Planning Application Ref: AW/71/18/HH

Location: 36 Kingsway, Aldwick

Description of works: Demolition of existing ground floor extensions to front of property, construction of a single storey rear extension and reworking of existing external hard and soft landscaping. This application affects the character and appearance of the Craigweil House Conservation Area.

| Dwg No.    | 601           |                          |

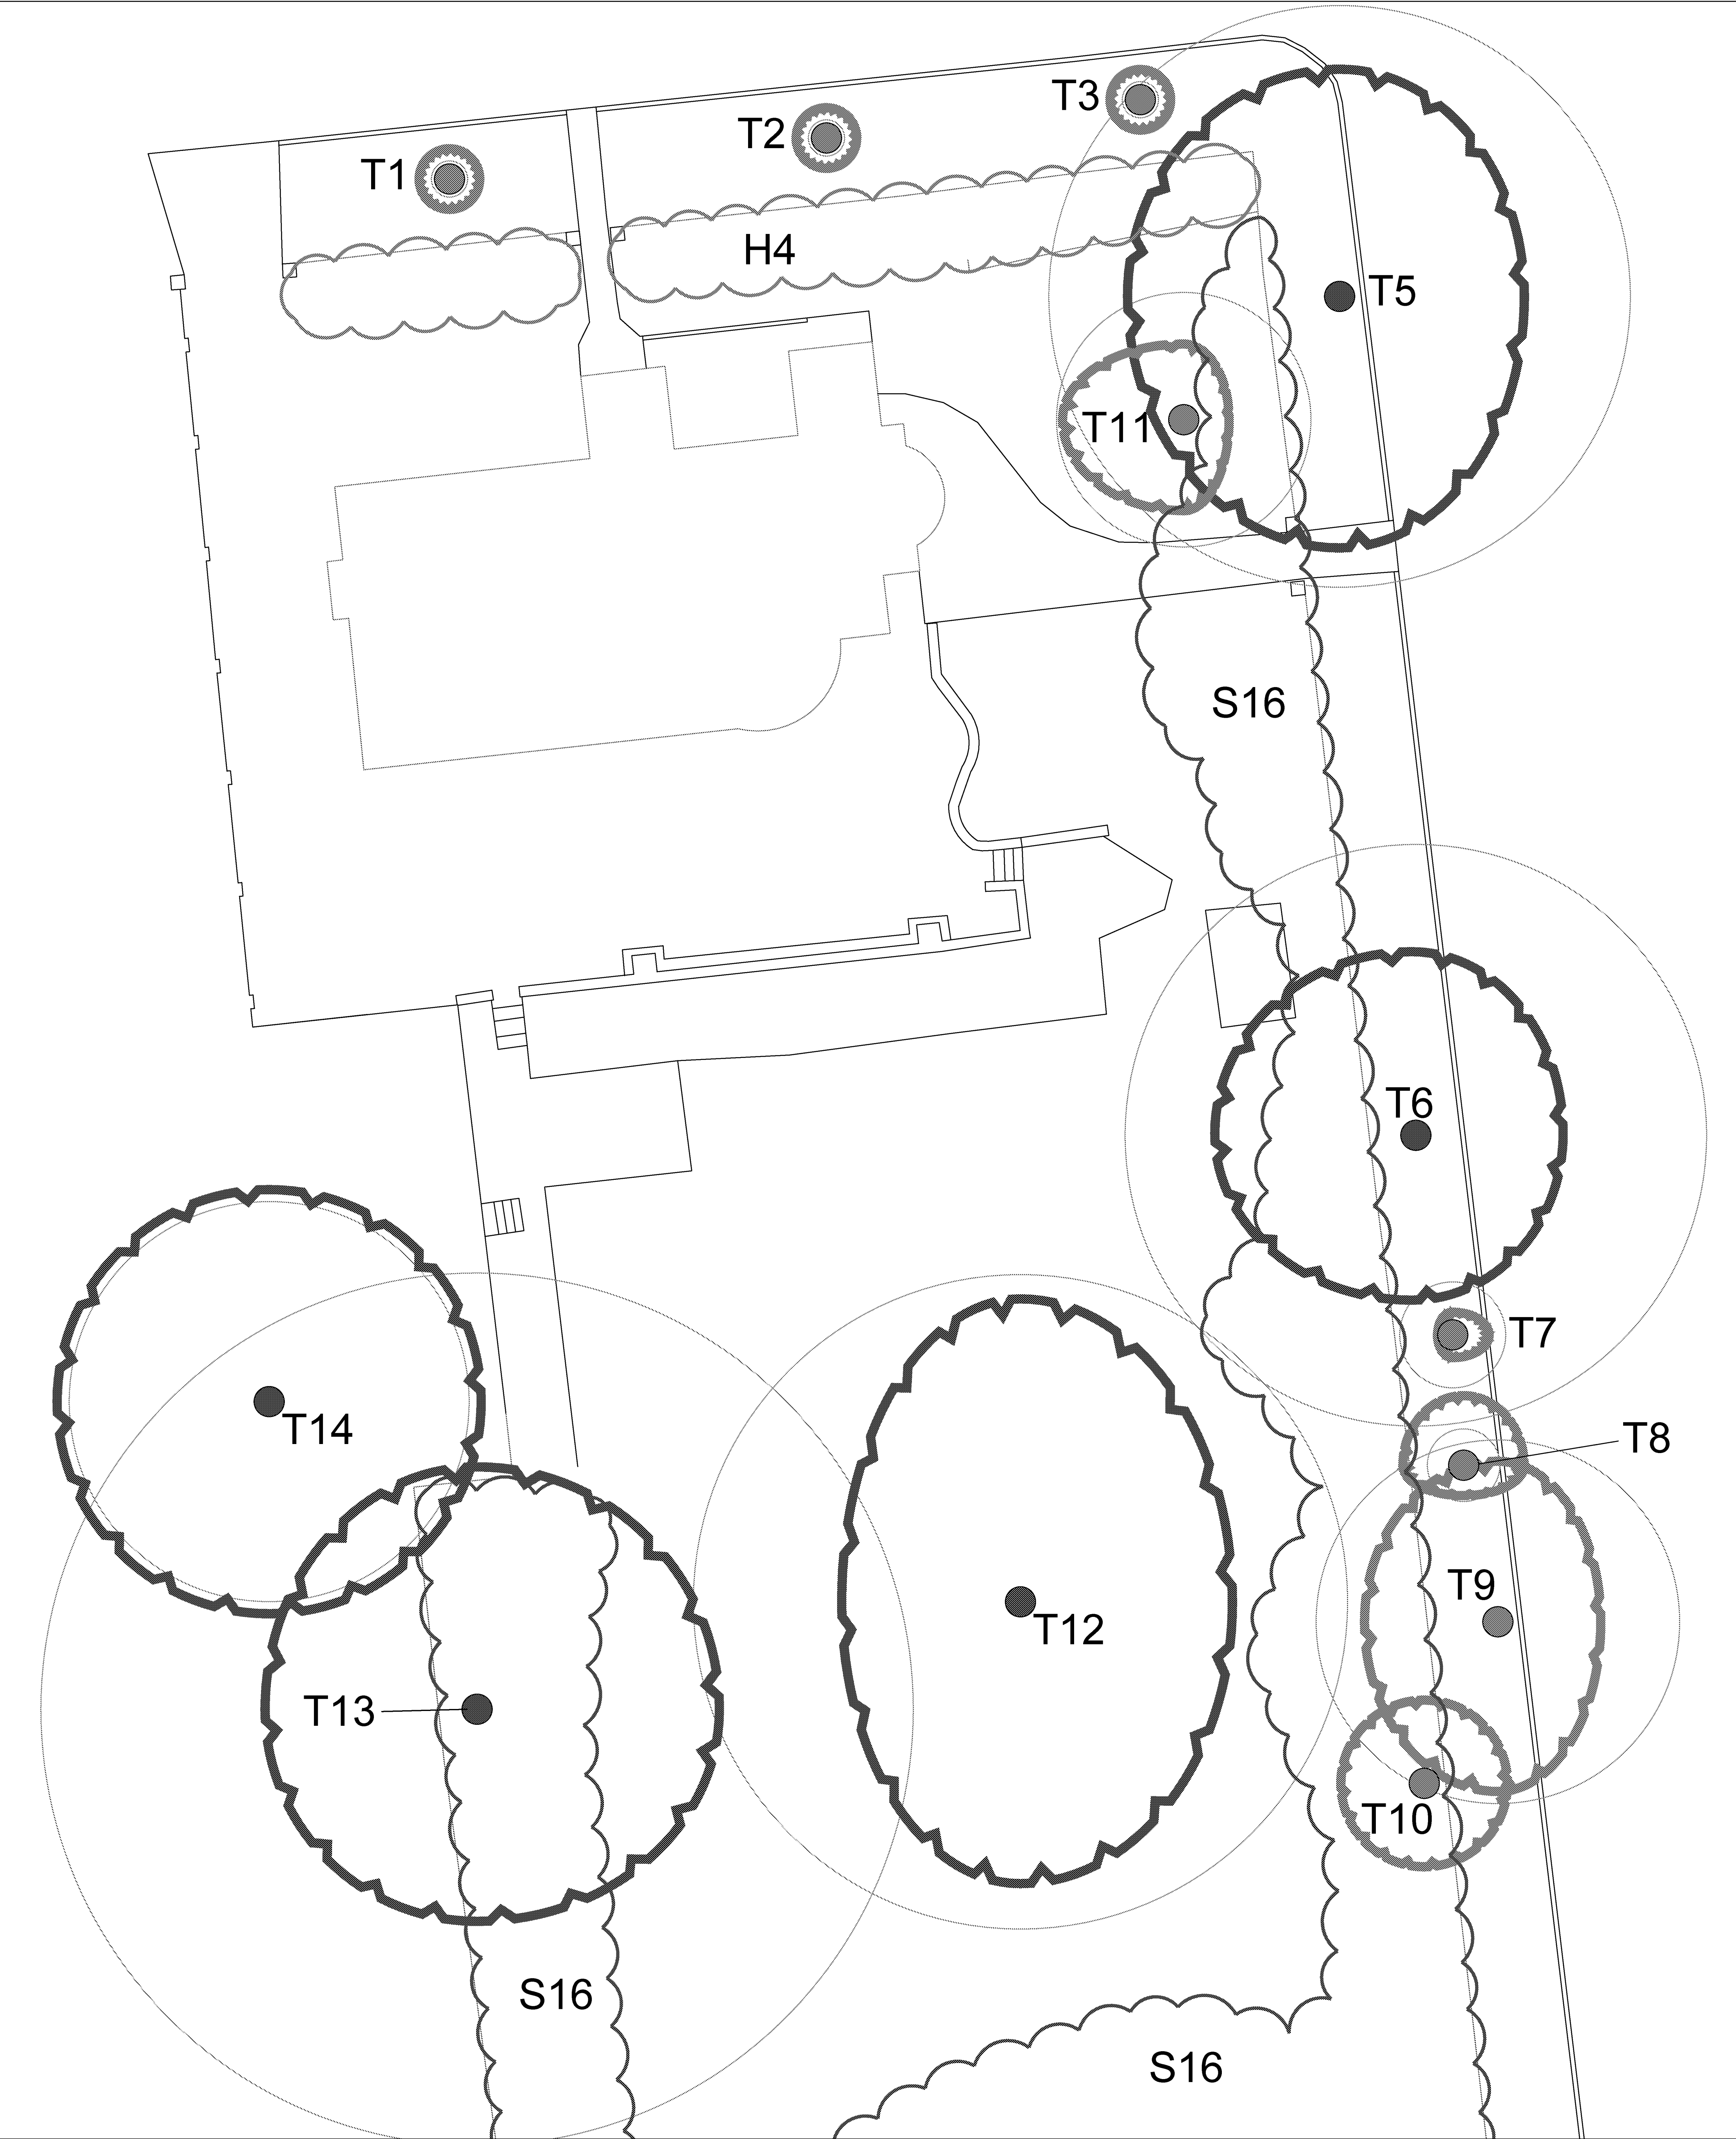
- The Tree Survey data mostly accords with the requirements of BS5837:2012 and I agree with the retention category ratings but there is a significant omission; namely the absence of Root Protection Area (RPA) measurements from the tree survey schedule or elsewhere in the AIA. This element of tree survey data is fundamental to achieve adequate tree protection.

- Of specific interest is T5 (horse chestnut), the subject of an Order (TPO/AW/5/16) and listed as T-1 on the associated Schedule. I measured its stem diameter at 1.5m height to be 895mm and not the recorded 800mm. This may seem a small matter but recognising the ideal RPA is significant in the context of this development proposal - which I return to later in more detail.

- As it stands, I must raise an **OBJECTION** to this application in its current form.
- RPA measurements (radial spread and area) must be added to the tree survey schedule to inform the process.

Drawing
Arboricultural Impact Assessment,
Arboricultural Method Statement

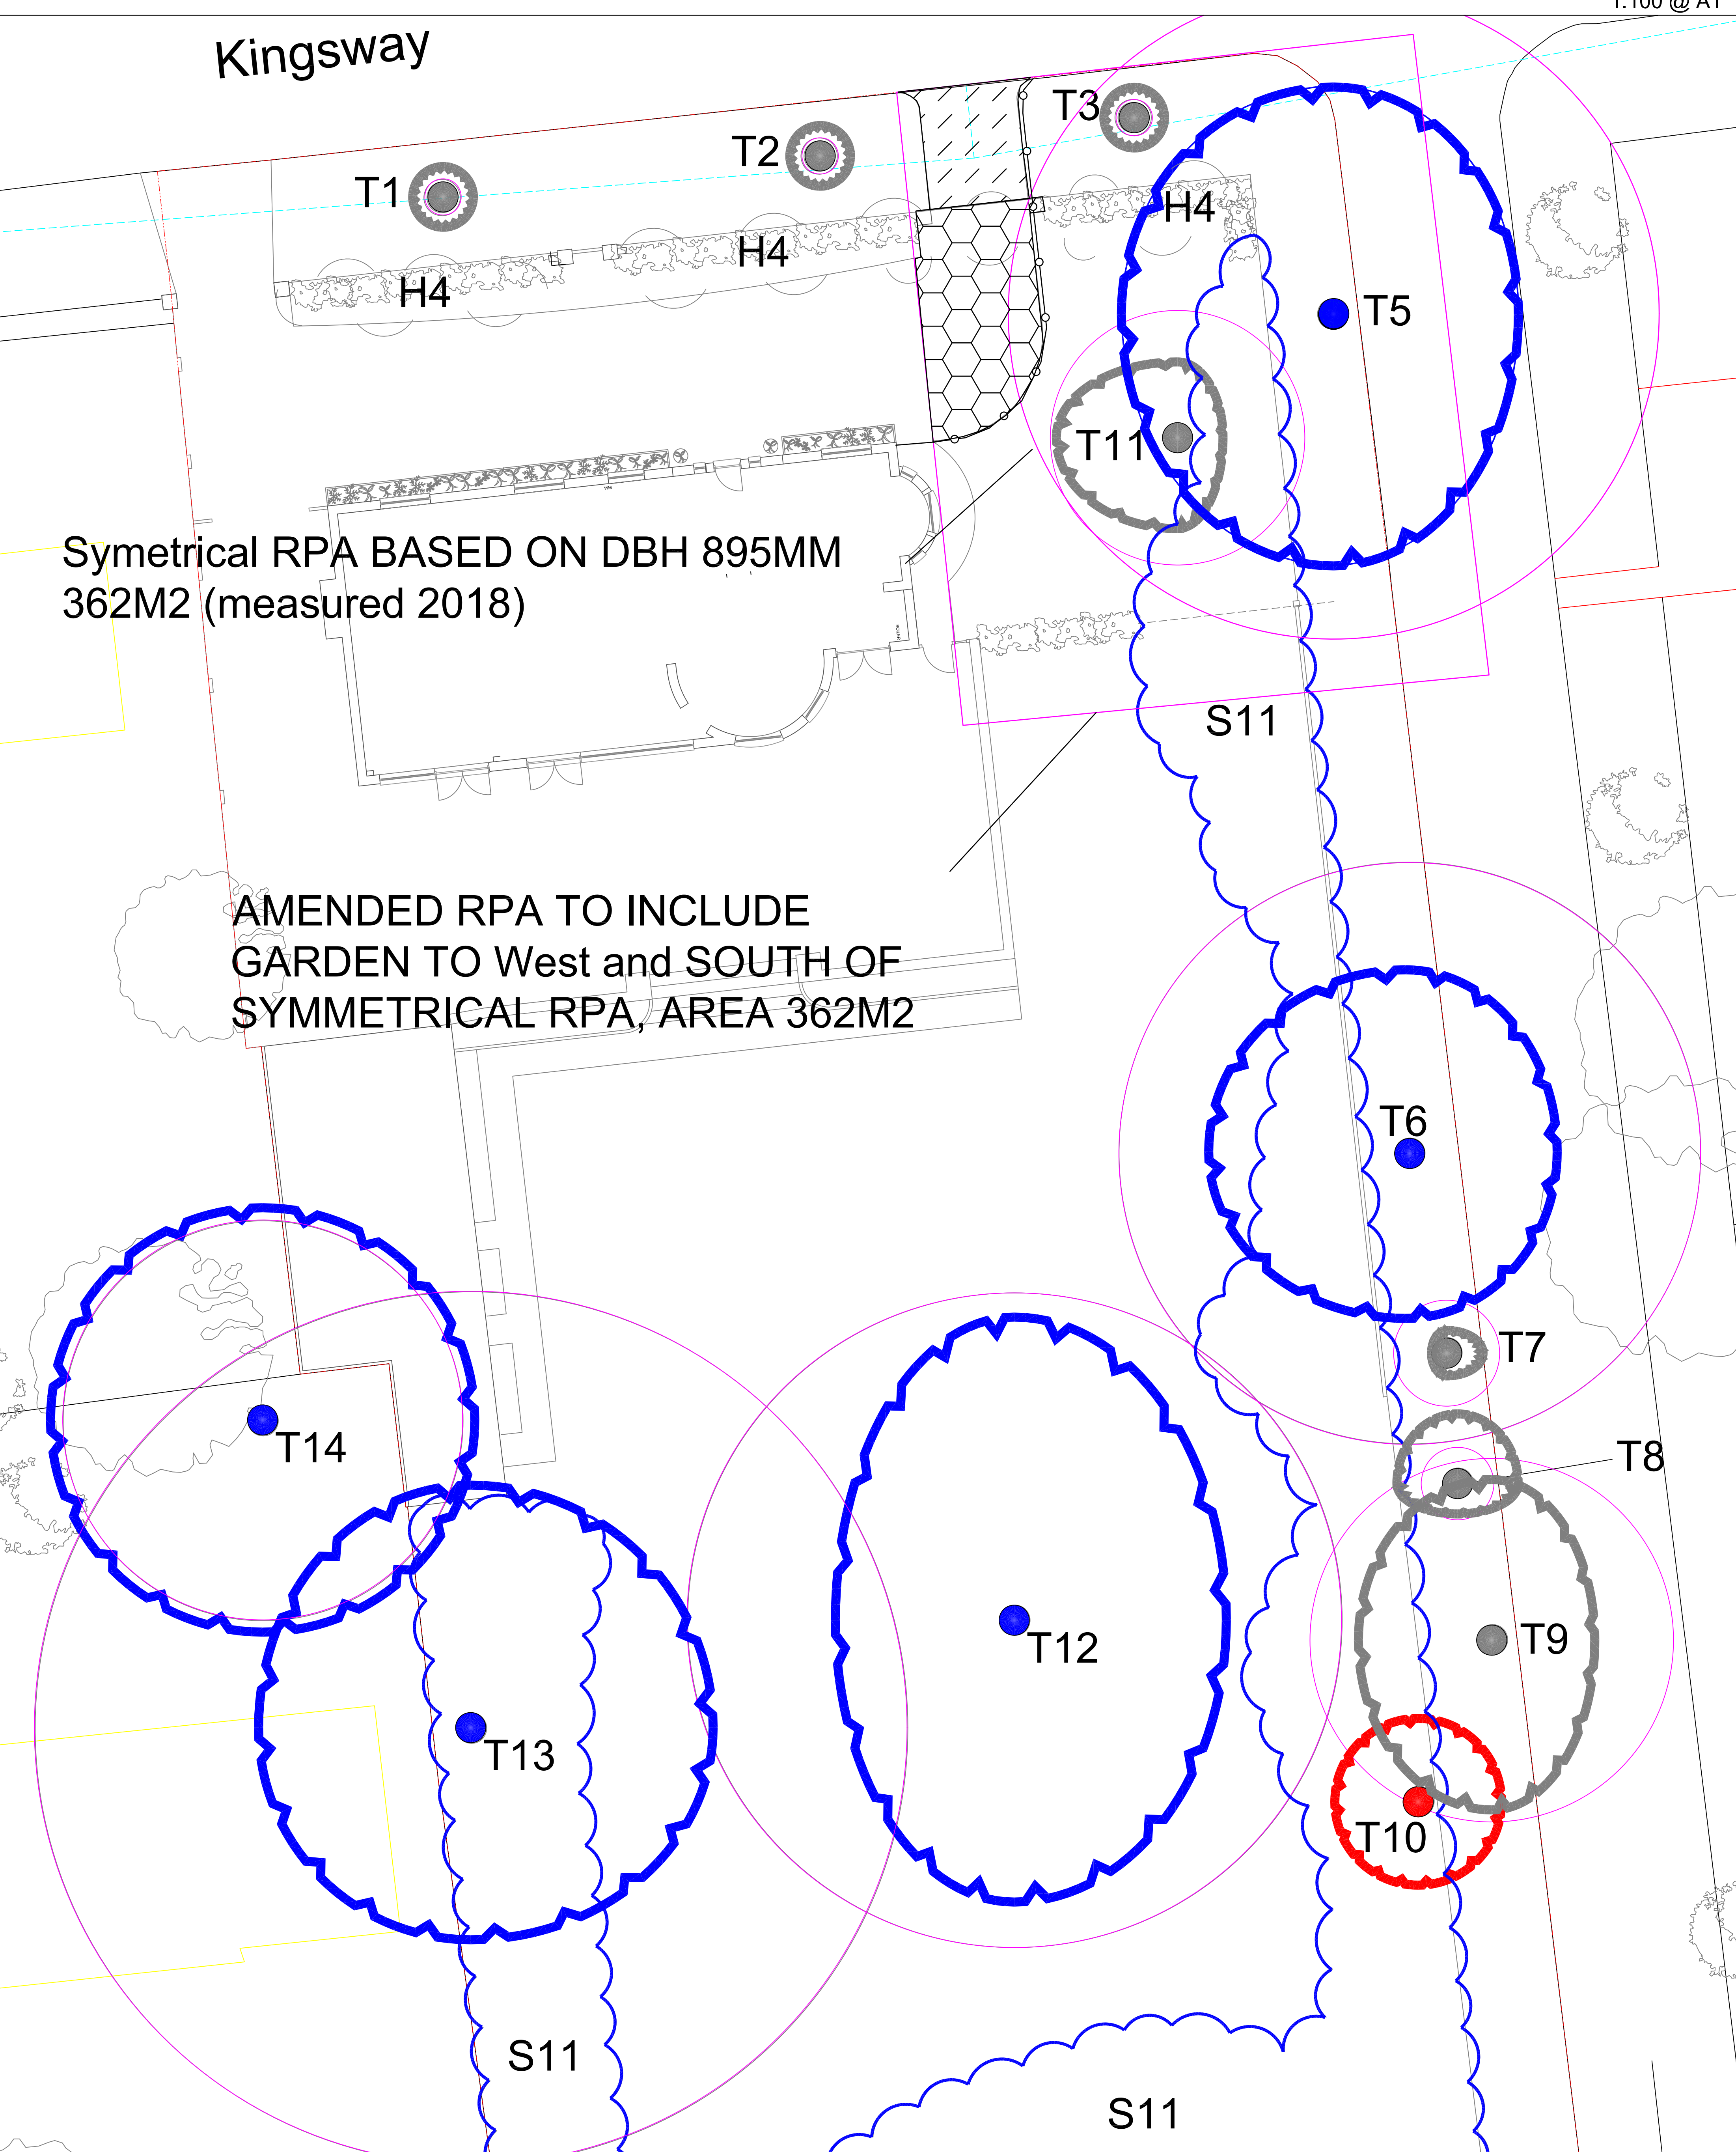
- The arboricultural survey information and associated documents/plans provided is well-intentioned and attempts to demonstrate adequate regard and respect for the tree population at and immediately around the site, but importantly fails to make an allowance for the likely impeded root development on the east aspect of T5.

- As it stands, the location of the proposed second driveway access construction is likely to impact severely on the root system of T5 with damaging consequences, such that it could decline rapidly.

- I would need to see a revised and asymmetric RPA for T5 that adequately compensates for the impediment to root growth as described earlier, before I could consider lending this scheme my full approval. This will require the re-positioning of the second driveway access further west; an alternative 'No-dig' method of construction in the proposed position would demand ground level changes that are unlikely to be acceptable to the applicant.

- I attach an indicative plan showing the desired RPA outcome for T5 to be adopted in a revised tree protection plan drawing, which can better inform a design. If necessary, I would be happy to meet the applicant's agent to discuss the methodology and measurements that support this plan.
